Submission to
State Significant Development Application SSD 7014

EXECUTIVE LOUNGE AND HOTEL BAR
FOUR POINTS HOTEL, SYDNEY

Document No. OBJ_365Kent

Drawing Title:
EXECUTIVE BAR - LEVEL 12

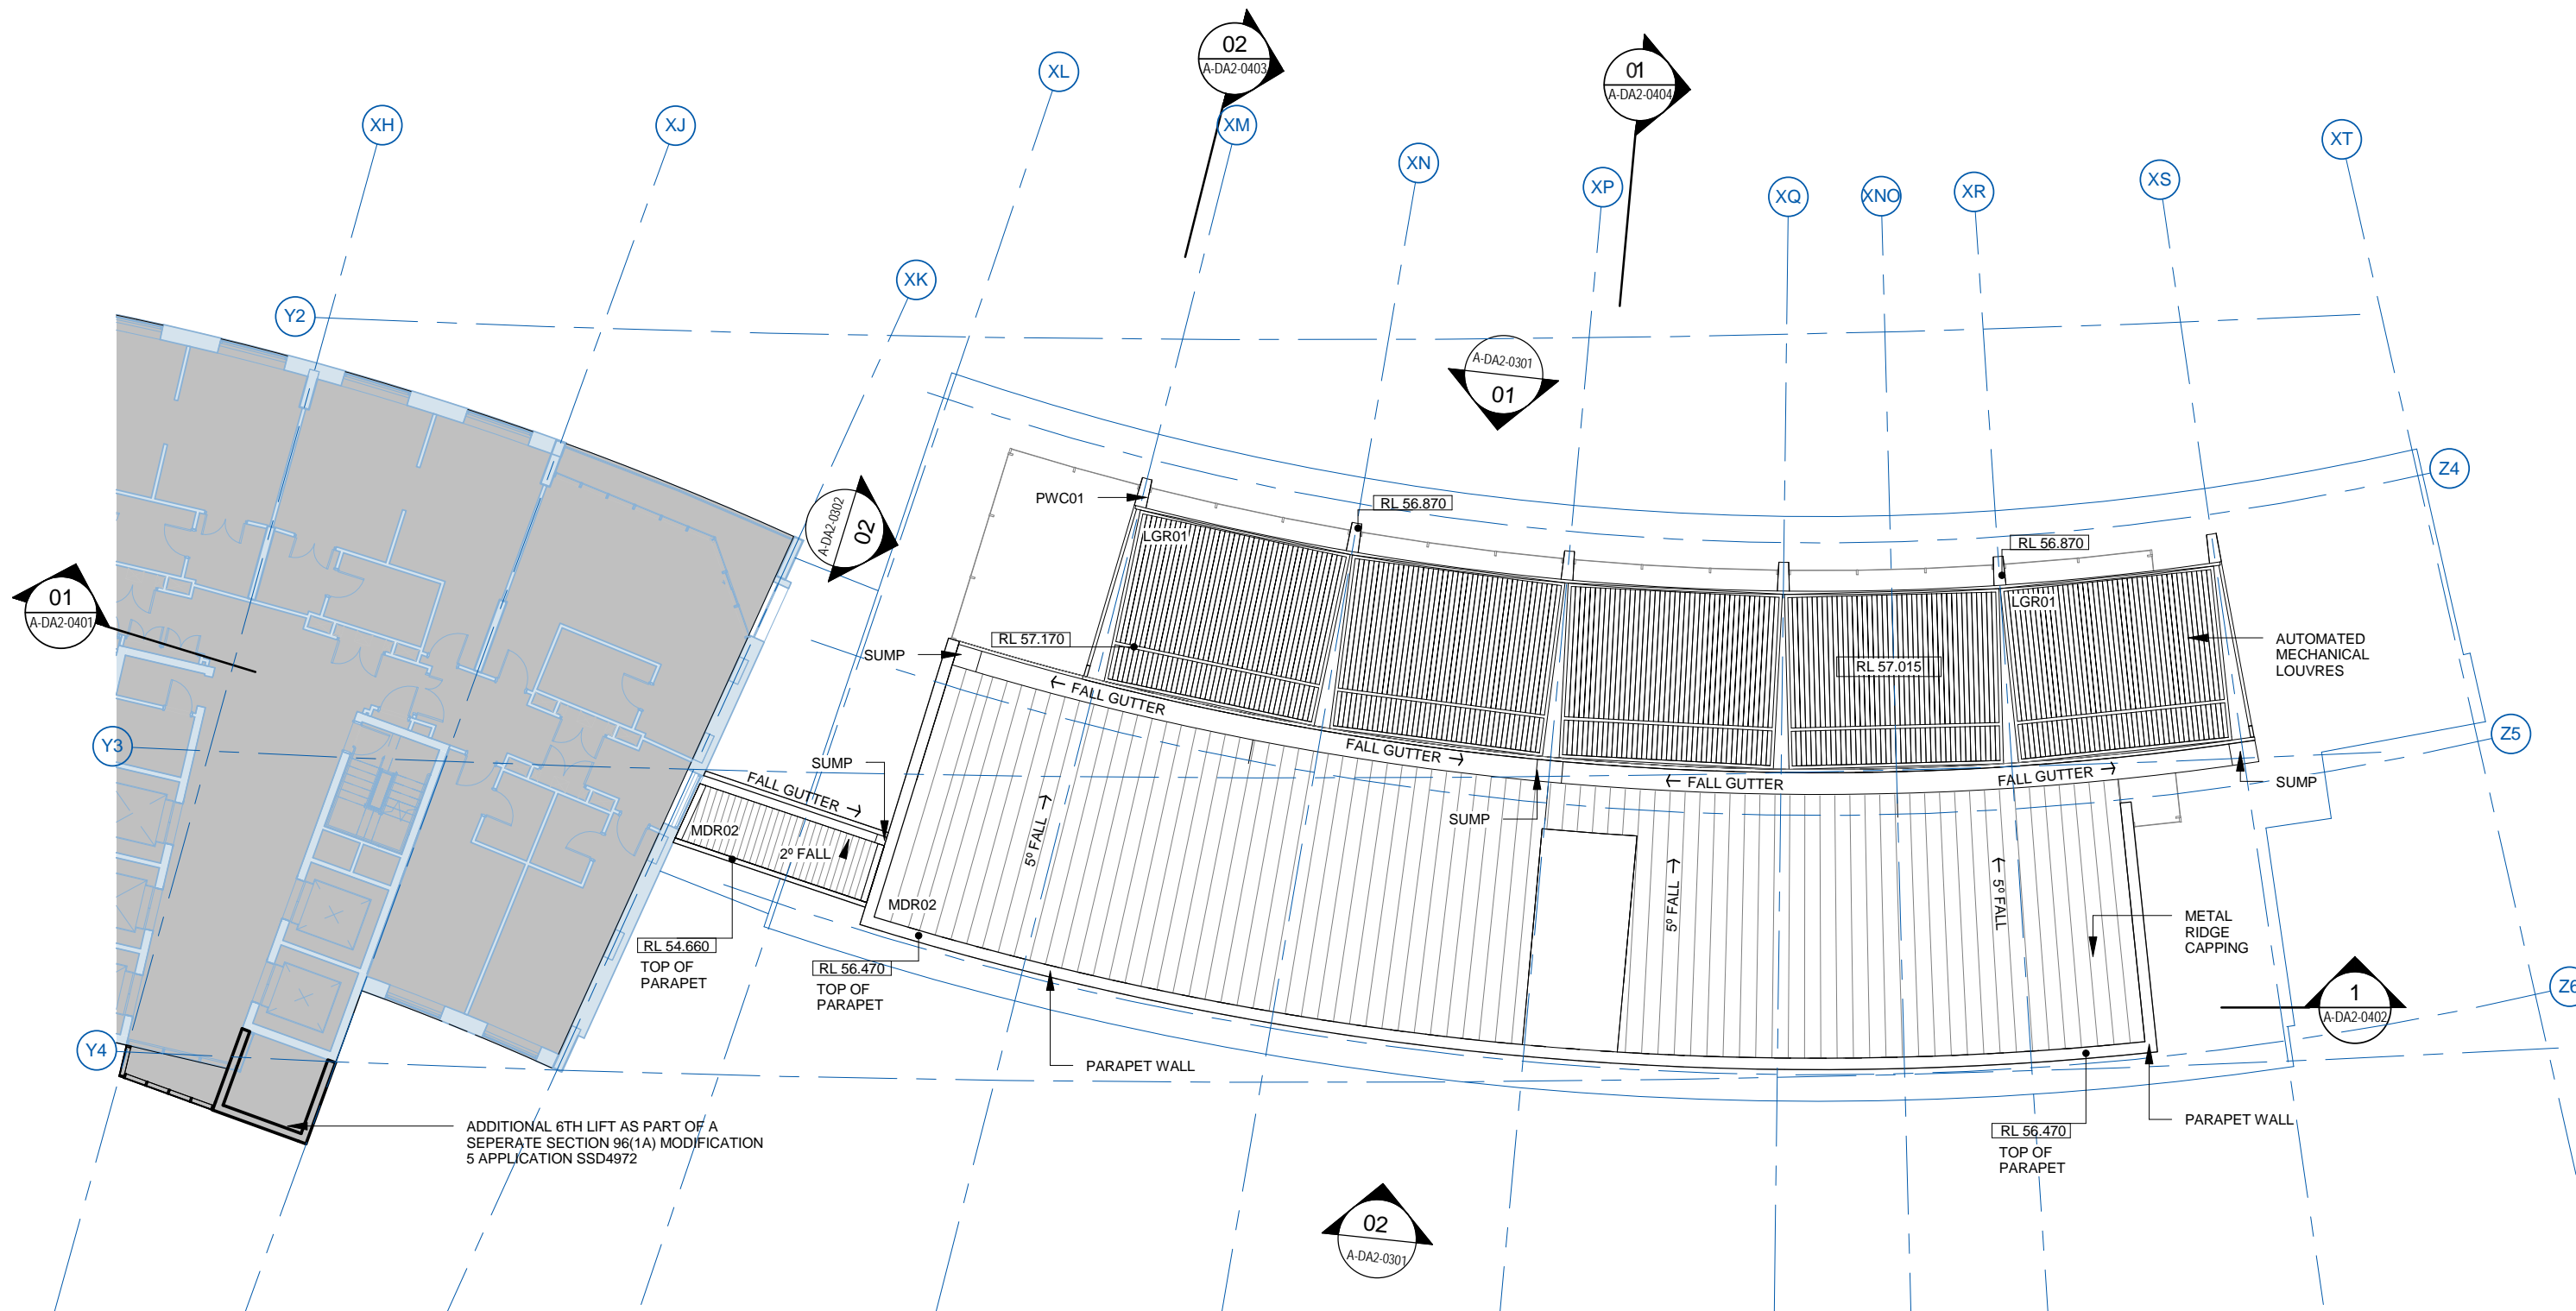
The whilst the proposed development provides a roof over the open air Level 12 Bar, the plans indicate that the roof will be operational as an openable louvered system. It is noted that the Operational Management Plan does not address the operation of this roof. Whilst it is assumed that this will be opened and closed pending weather events, the closure of this roof provides a vital role in acoustic mitigation, especially given the line-of-sight between the proposed development and the upper levels of our clients' site.

- Recommendation 8: The operational roof of the Level 12 Bar is to be closed between the hours of 12:00am to 7:00am daily.

However, this is not true as there is a direct line-of-sight from the upper levels of our clients' site to the Level 12 Bar should the Louvres be open. Furthermore, the assessment does not take into consideration redirections, reflections or reverberation of sound due to the ongoing operation of the Level 12 Bar, especially in a 24 hour format.

Drawing Number:
A-DA2-0204

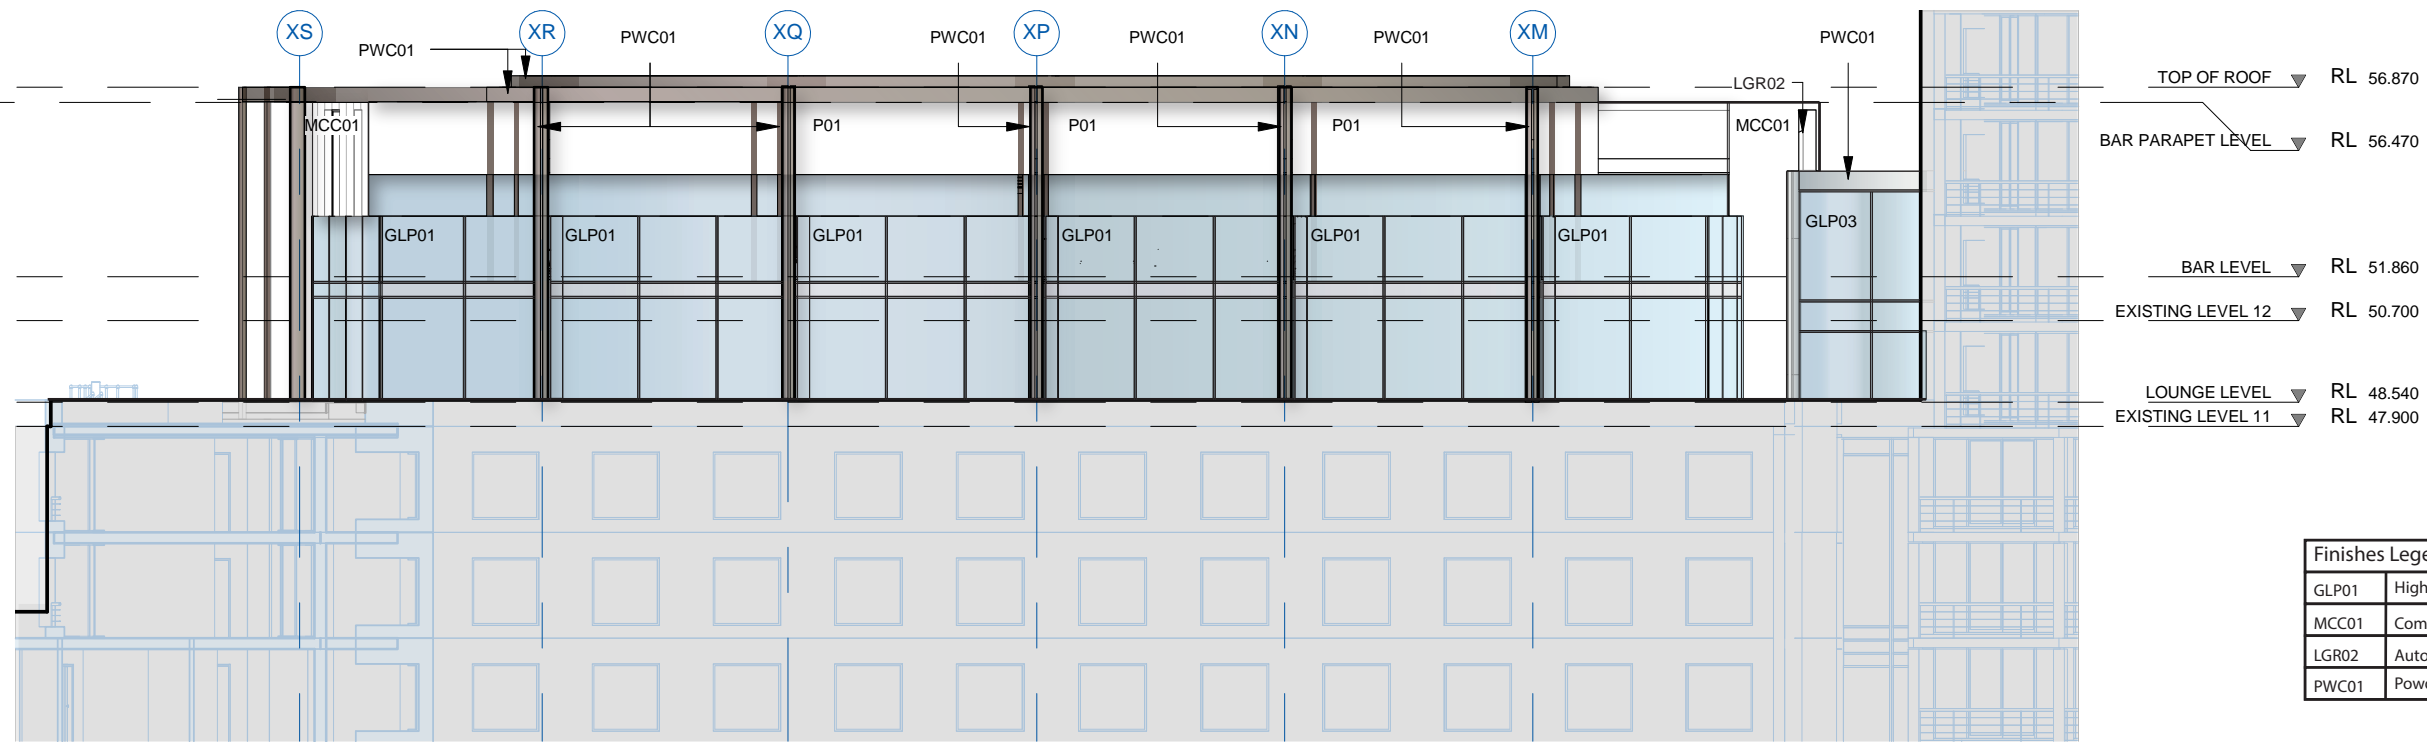
It is noted that there has been no assessment of the potential impacts of the mechanical plant room, which is likely to be visually screened by louvres, however does not provide any details for acoustic attenuation.

Recommendation 9: Acoustic Assessment be revised to consider the cumulative impacts of the background sound levels and patrons. The revised assessment should also include an assessment of the proposed mechanical plant and provide recommendations for acoustic screening. This assessment should in increments, within the whole of a 24 hour period as proposed.
